CITY OF ALBUQUERQUE

July 13, 2022

Re: Bosque on Eubank
5210 Eubank Blvd. NE
30-Day Temporary Certificate of Occupancy
Transportation Development Final Inspection
Architect's Stamp dated 9-2-20 (F21-D047A)
Certification dated 6-06-22

1 ARCHITECTURAL SITE PLAN
SCALE: 1" = 10'-0"

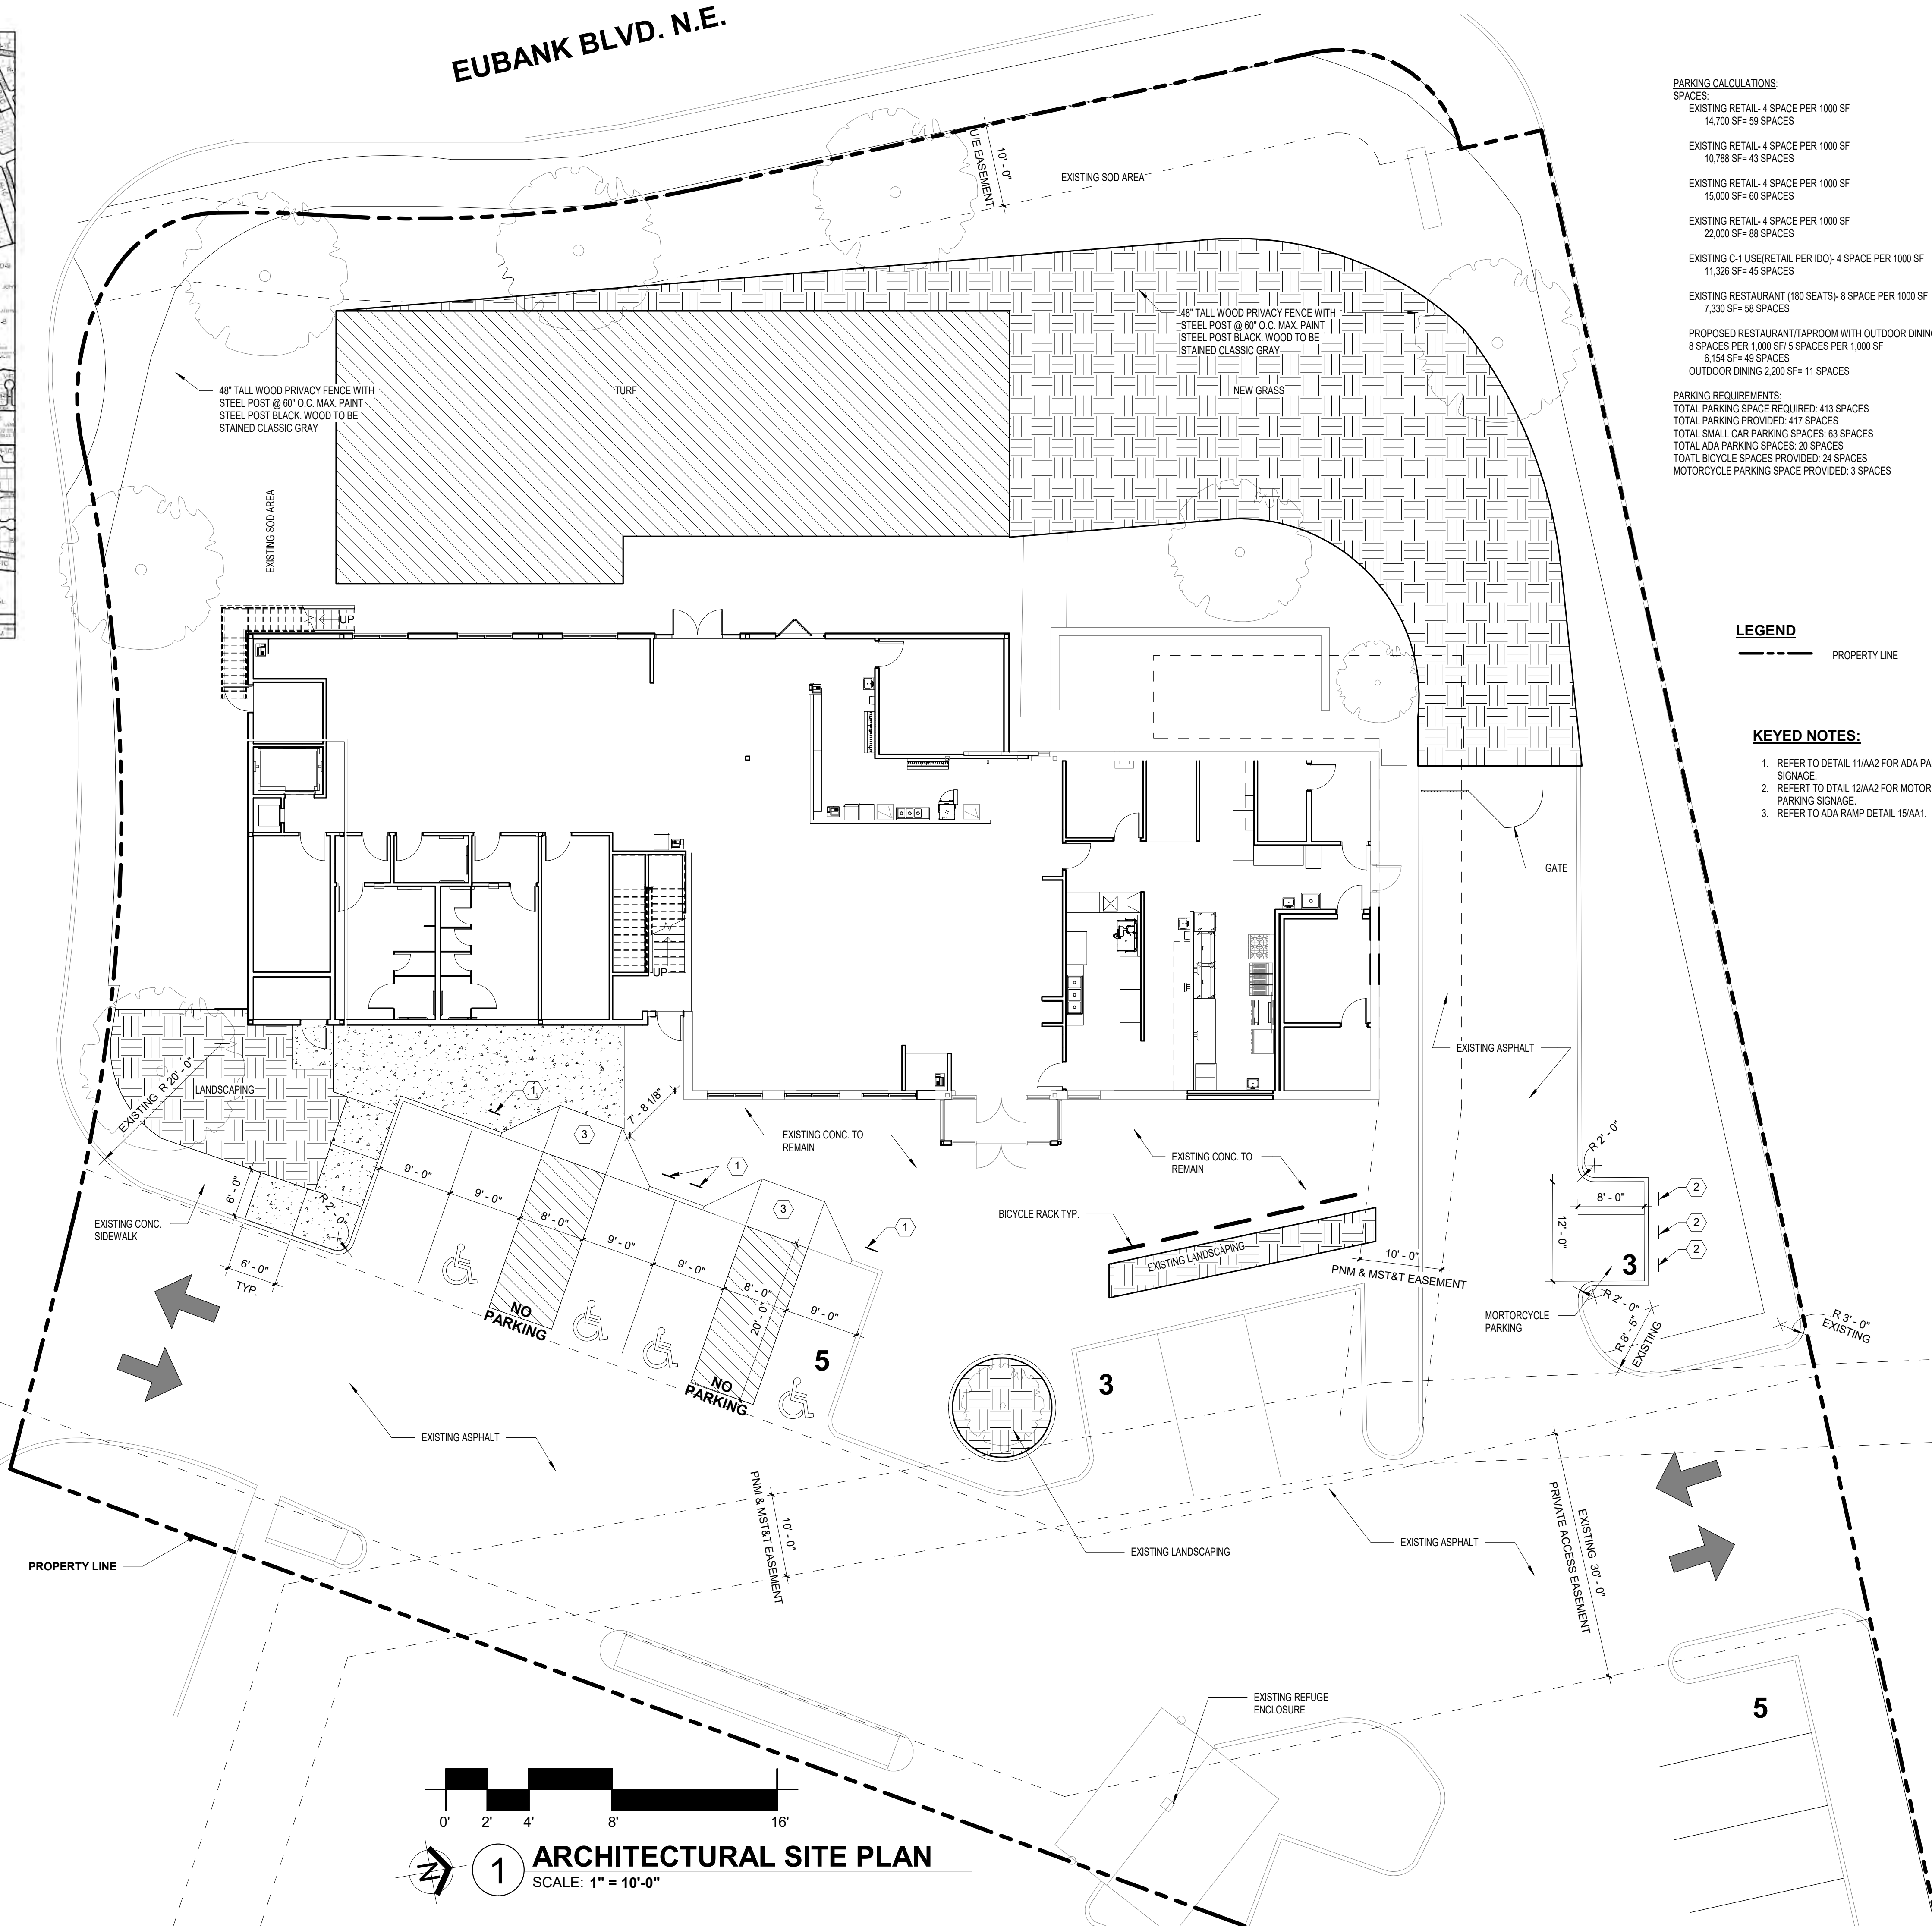
- 6' ADA pathway need to be provided from ADA aisle to the building entrance. Site plan showing 7' – 8 1/8" but per site visit there is only 4' have provided. Please see attached picture.
- Keynote 3: the new ADA ramps are not meeting the ADA requirements. The running slope for the landing area for both ADA ramps is 5.6% and 6.7%, which should not exceed the max. 2%. The cross slope for the ADA ramps' wings (flared sides) exceeds the maximum (2%). Please rebuild the ADA ramps per city standard.
- Anchor down Bike Rack.
- The ADA accessible parking sign must have the required language per 66-7-352.4C NMSA 1978 "**Violators Are Subject to a Fine and/or Towing.**" Please call out detail and location of signs. This language is missing for one of the signs.
- Please fix the site address on the Traffic Certification.
